**BARANGAROO HEADLAND PARK AND NORTHERN COVE MAIN WORKS  
PROPOSED MODIFICATION TO APPROVAL MP10\_0048  
RESPONSE TO PROFESSOR JAMES WEIRICK SUBMISSION**

Encl: Response to submission by James Weirick on MOD3 application

BARANGAROO HEADLAND PARK - UPDATED (S75W) SITE PLAN

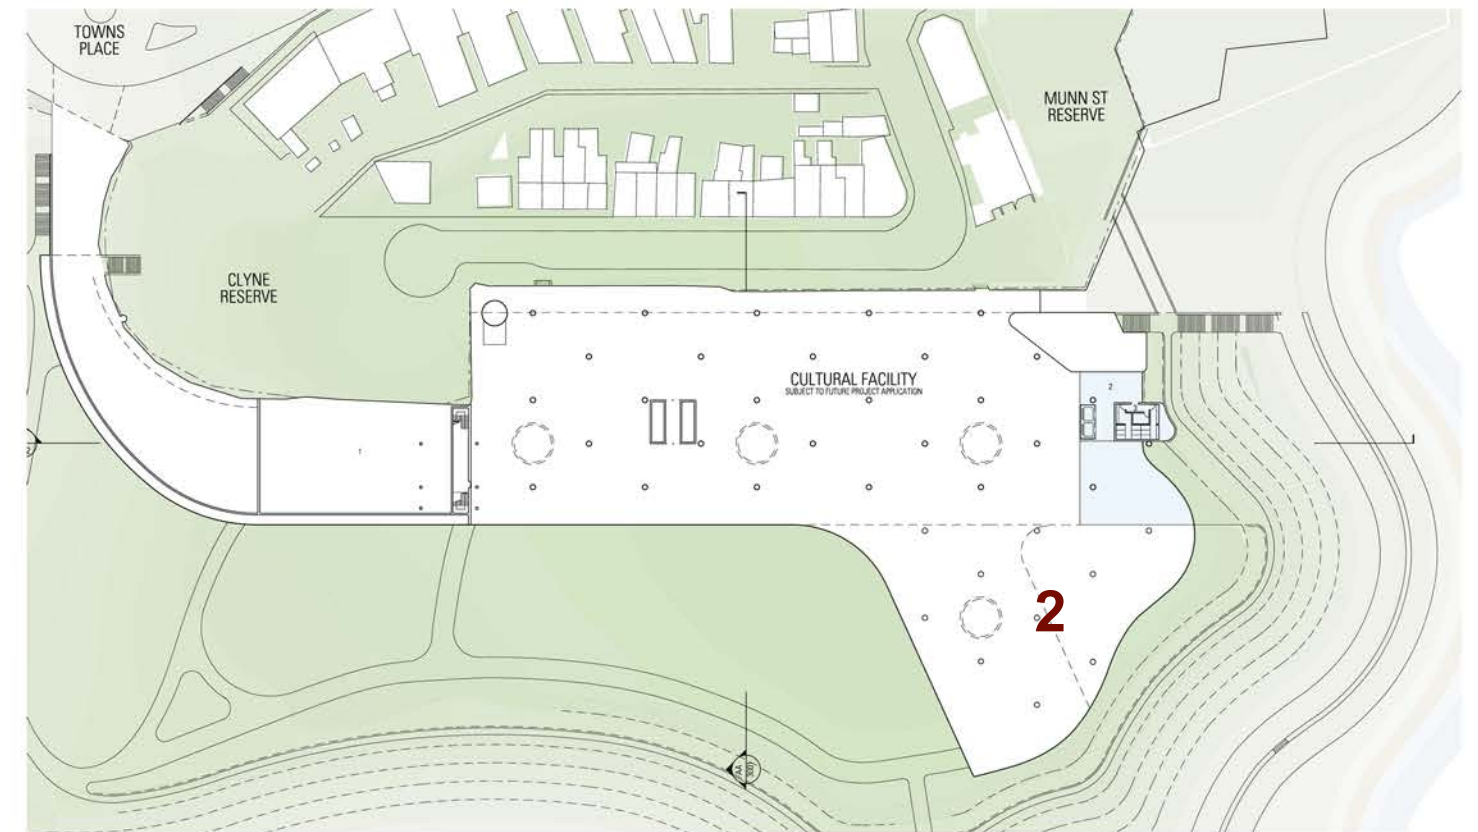
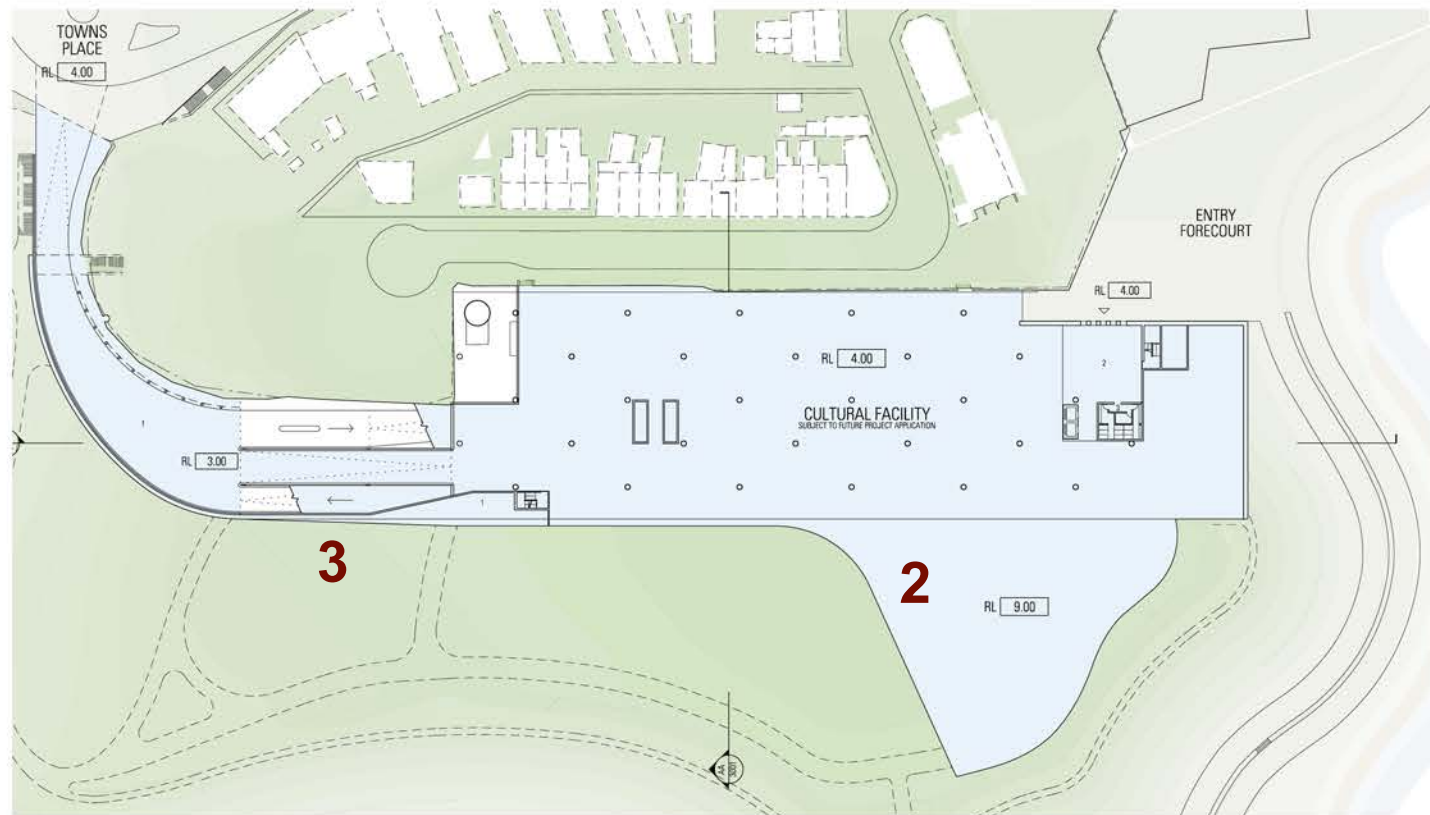
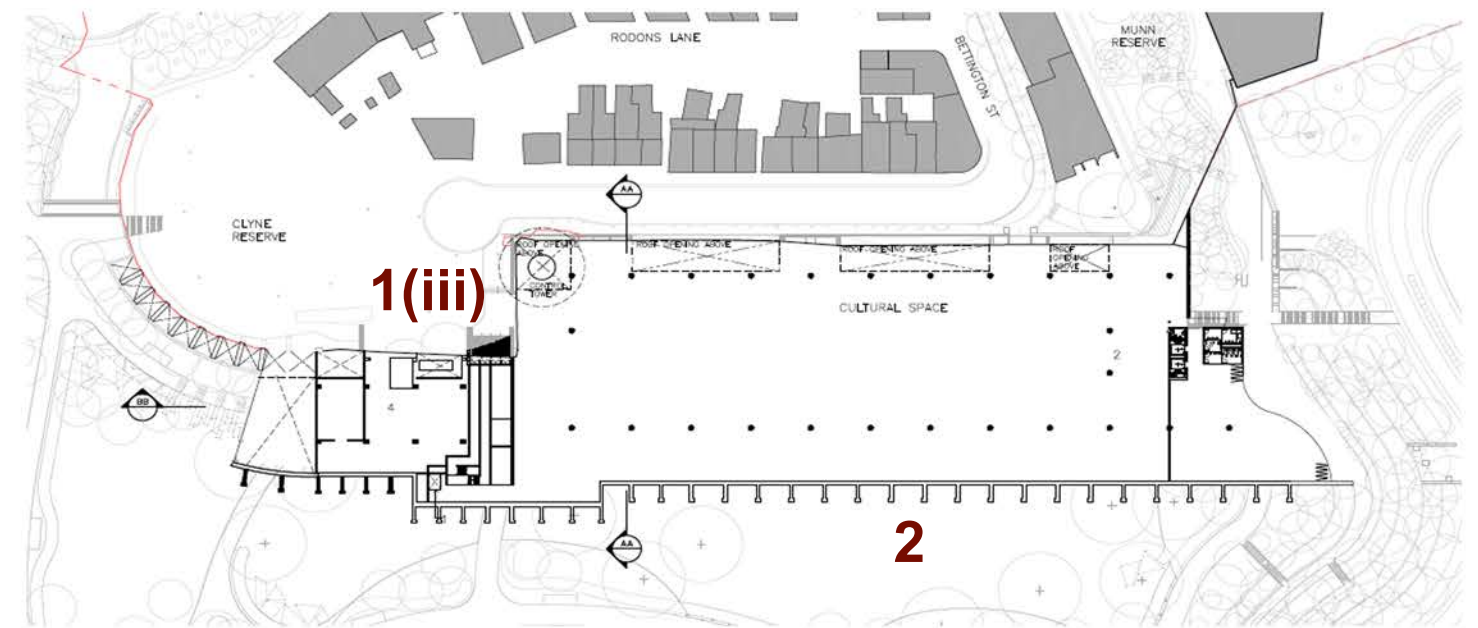
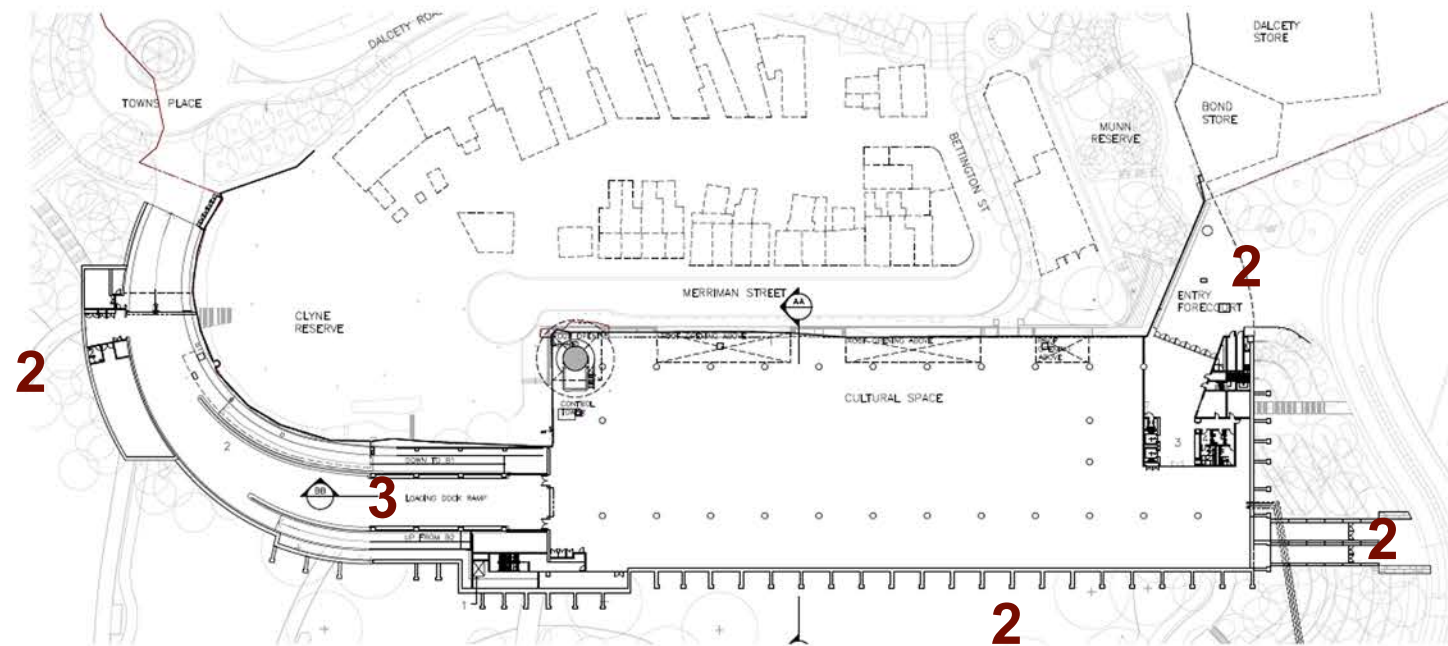
**Recommendation 3:** The radically redesigned southern entrance to the Cultural Facility proposed in MP 10\_0048 MOD 3 must not proceed. To maintain the design excellence of the harbour foreshore approach to this facility and the cultural significance of this major public work, the original 'bridge and void' design of the entrance must be retained, ensuring that ambient light - and at times shafts of sunlight are brought to play at ground level around the entrance, animating the public address of the place.

**Recommendation 4:** The design of the new southern fire exit from the underground Cultural Facility must be re-conceptualised and re-presented as an integrated architectural composition

with the public entry to the facility a few metres to the east, reliant on structure, scale, proportions and materials to 'read' as visually subservient to the public entry- not tree planting within the egress from the fire exit as at present, which is unlikely to meet code.

The third bridge from Merriman Street to Headland Park proposed in MP 10\_0048 MOD 3 should not proceed. In addition to the legitimate concerns raised by the residents of Merriman Street about this proposal in terms of the safety and security of their neighbourhood, the bridge will have an unacceptable impact on the amenity and spatial quality of the underground Cultural Facility by 'closing in' a significant section of the void along the sandstone cliff, limiting ambient light conditions and the penetration of sunlight, and closing off vistas to the sky.

The land bridge concept re-connects Munn Reserve / Argyle Place to the Headland Park, allowing Munn Reserve to become a key park entrance. The Authority is partnering with City of Sydney in the delivery of public domain improvement in Millers Point from the "Harbour Village North Study" to improve these connections.

The architectural finish to the cultural facility entrance at the foreshore promenade level has been preserved until a tenant for the space has been secured. The long-span structural solution at the southeast entrance allows for maximum flexibility of architectural feature in the future without disrupting the integration of the underground space with the naturalistic landform. The recessing of the cultural space entry doors under the land bridge could be modified in the future to provide a new entrance statement under the edge of the land bridge while maintaining an important forecourt space.

The architectural composition of the fire egress has been integrated into the surrounding landscape. The impact of the fire egress onto the foreshore is minimised by keeping the ceiling height below the first bush-retaining terrace, thus reducing the break in the continuity of the terraces. Trees will be planted in the area in front of the doors to further integrate into the landscape. Trees along the northern cove side of the foreshore path have been added, which will screen the distant views from Barangaroo Central. Because the egress is set perpendicularly back within the bush landscape, the visual experience walking along the foreshore promenade will remain relatively unbroken from a distance.

The respondent's proposed alternative for the fire egress (i.e. direct integration with main entry) was considered early in the design development phase. Unfortunately, the Building Code of Australia does not permit more than 50% of occupants to egress via the main entry. The certifier has validated the current proposal.

The Building Code consultant, the Fire Engineer and the certifier have considered the suitability of trees located in the path of egress. From an overall available width of 8.6 metres, the required width of egress of 7.0 metres for that exit would be maintained.

The merits of this change have been dealt with in some detail, both in the modification application and in the subsequent response to submissions.

As noted in the modification application, the aim of the additional pedestrian access is to improve the integration of the parkland for present and future occupants of Millers Point and in doing so, help develop a sense of ownership of

This aspect of the proposed modification is supported by the City of Sydney. The City has noted that the additional pedestrian access would improve permeability along eastern edge of the park.

The inclusion of the third bridge will still provide sufficient natural light penetration into the cultural space.

BARANGAROO HEADLAND PARK - UPPER FLOORS

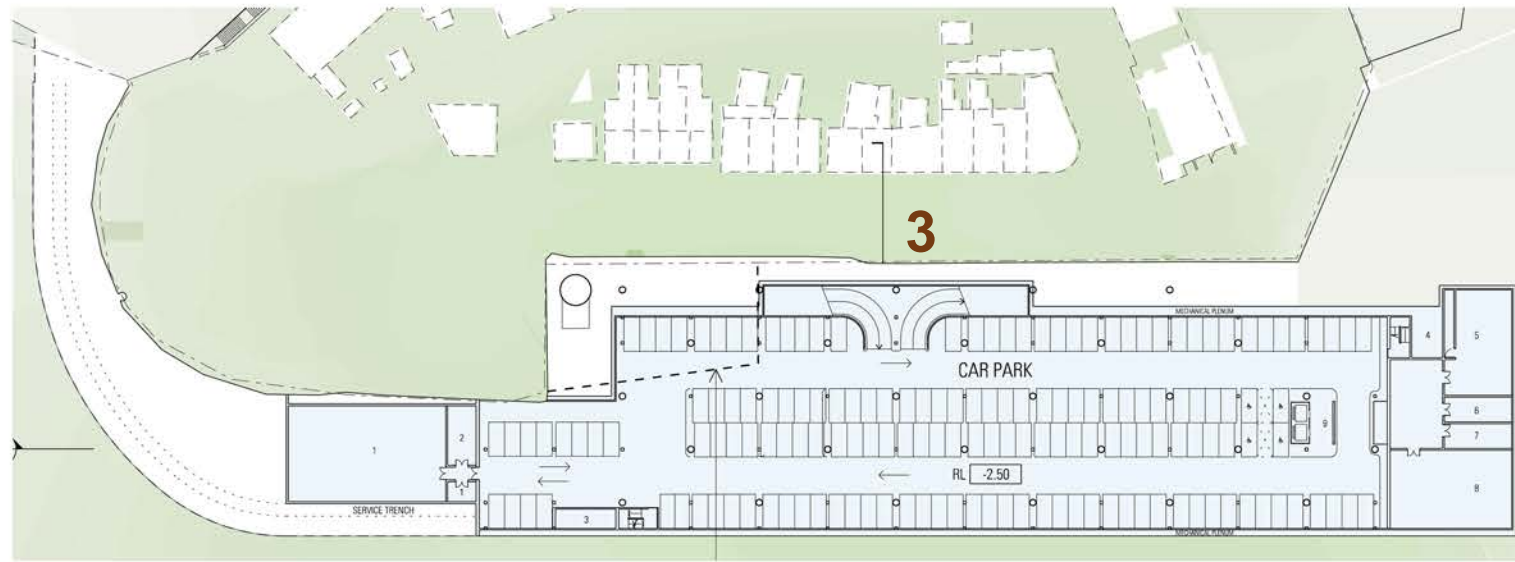
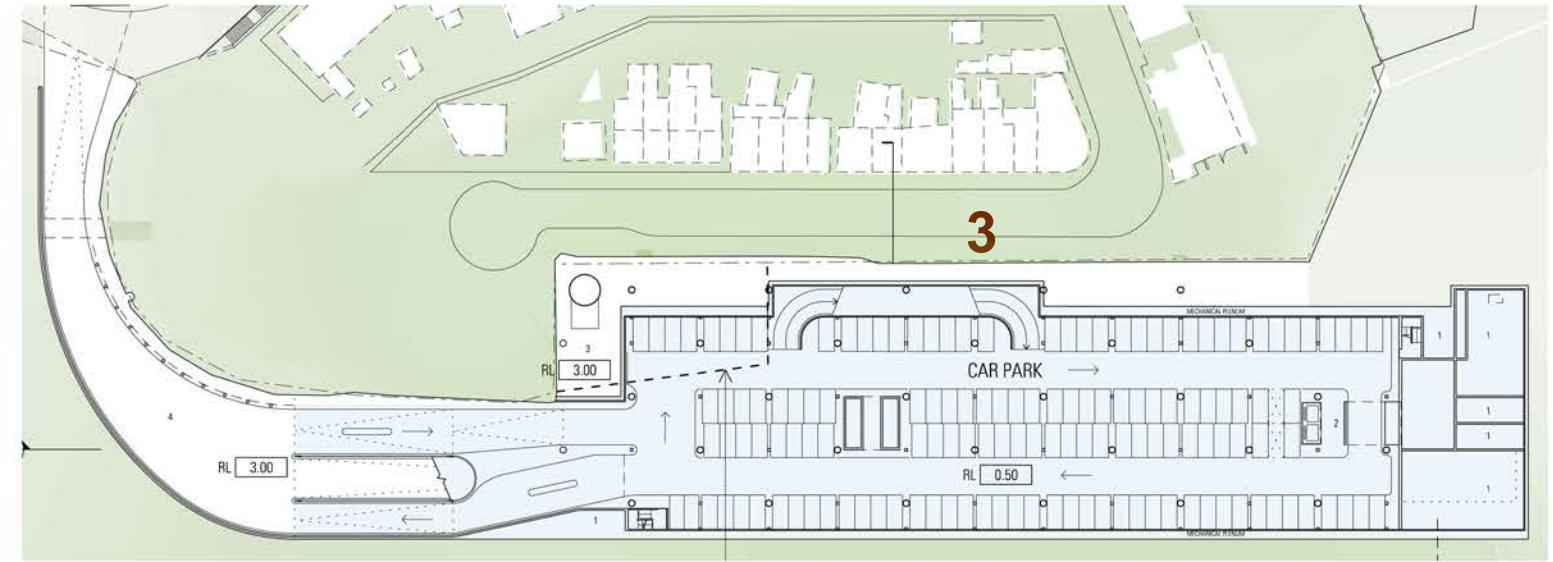
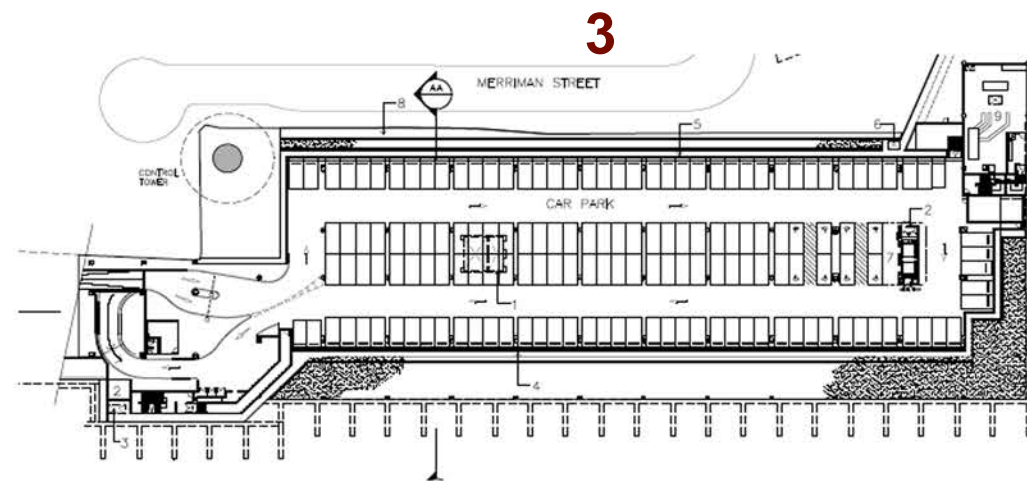
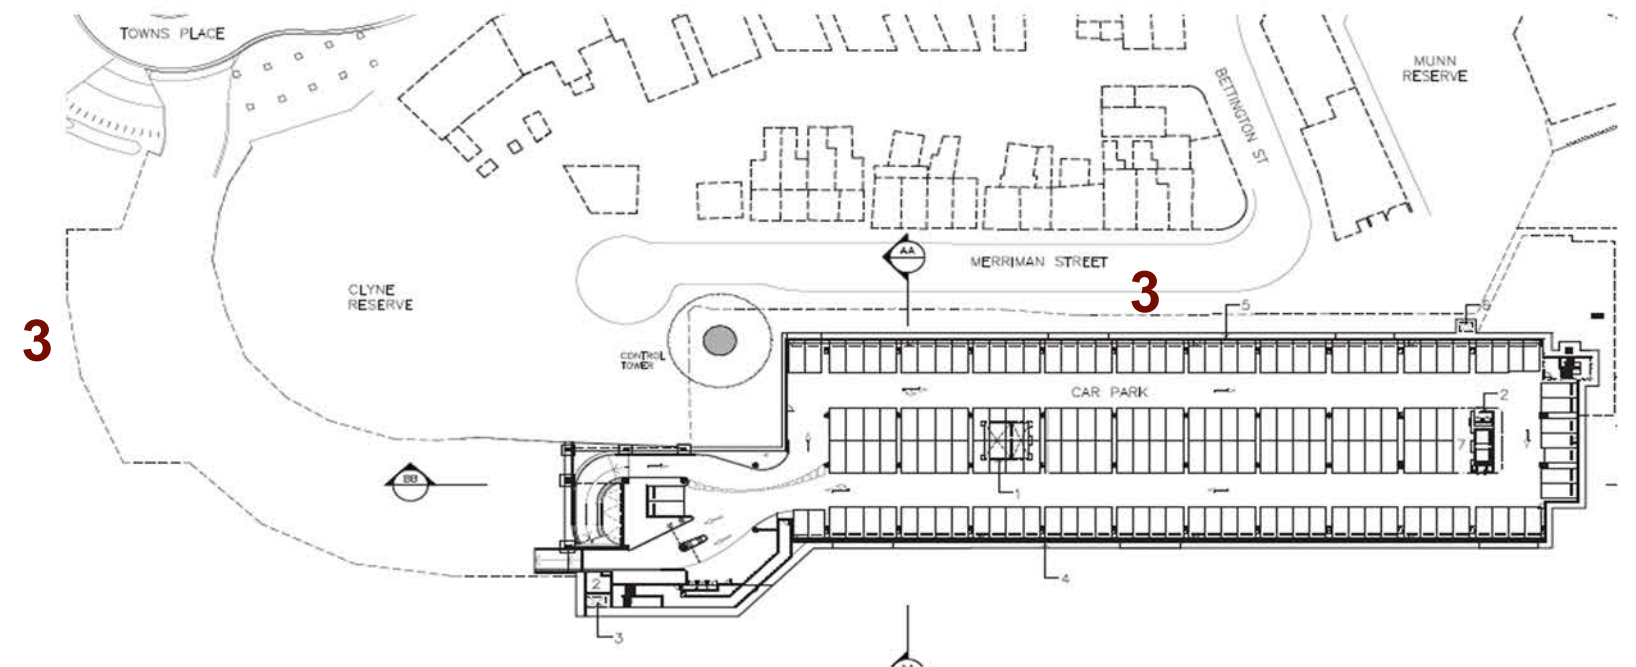
<b>Recommendation 6:</b>	The significant reduction in the size of the Cultural Facility envelope at Headland Park proposed in MP 10_0048 MOD 3 should not proceed. As the March 2013 report of the NSW Creative Industries Taskforce indicates, considerable progress has been made in the investigation of cultural futures for Barangaroo. The configuration of the Cultural Facility envelope should be maintained with maximum physical potential and flexibility, as approved as part of the original MP 10_0048 Project Application in 2011.
--------------------------	---

The Cultural Space has not significantly reduced in size. The Main Works Environmental Assessment describes the flexibility proposed for the Cultural Space, providing for an initial volume of 75,000m<sup>3</sup> with a maximum total volume of 100,000m<sup>3</sup>. The proposed volume is approximately 80,000 cubic metres and is consistent with the project approval.

Apart from two plans where the “piano shaped extension” to which the respondent refers is shown, most sections and other references show the space in its rectangular footprint. No sections in the application set show this ‘piano shaped extension’ in recognition that flexibility for further design development was desired. The ‘piano shaped’ extension was a potential ‘add-on’ to increase the maximum volume achievable within the Headland Park mound.
